CITY OF ALBUQUERQUE

April 3, 2024

**Re: Precision Eye Center
7521 Alameda Blvd NE
Request for Certificate of Occupancy- 30 Day Temp
Transportation Development Final Inspection**
Engineer Stamp date 4-20-23 (C19D070)
Certification dated 4-22-24

10 BIKE PARKING
SCALE: NONE

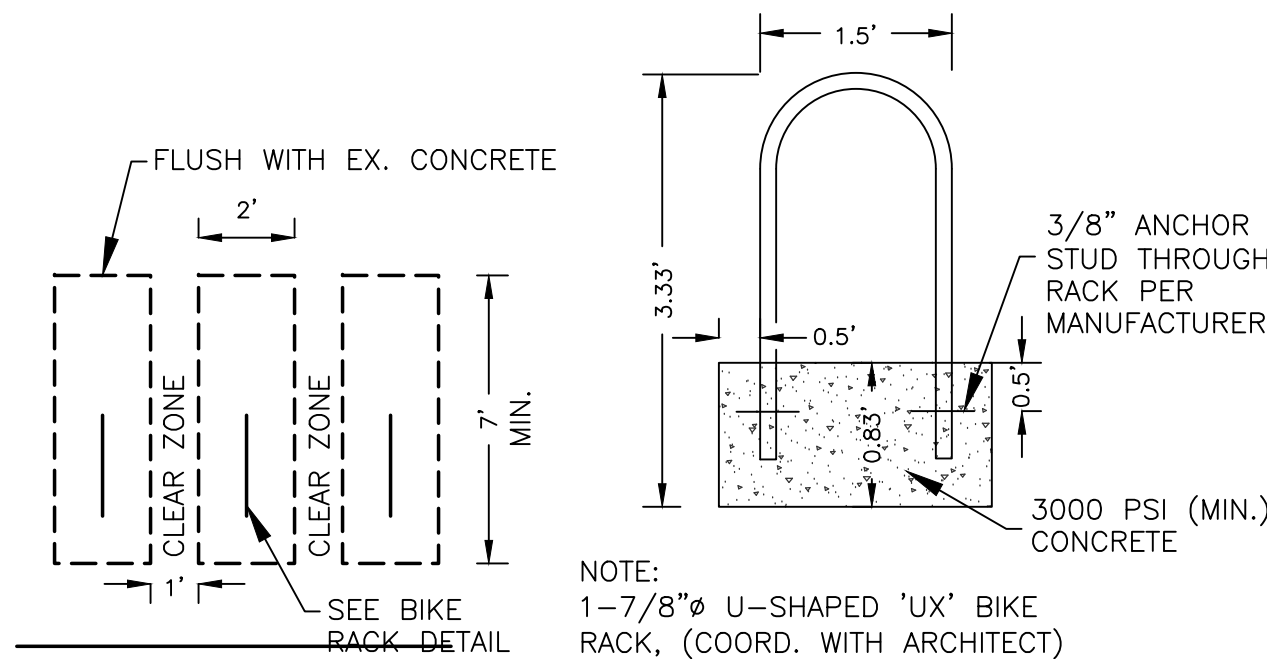
1. The bike racks are to be installed per plan.
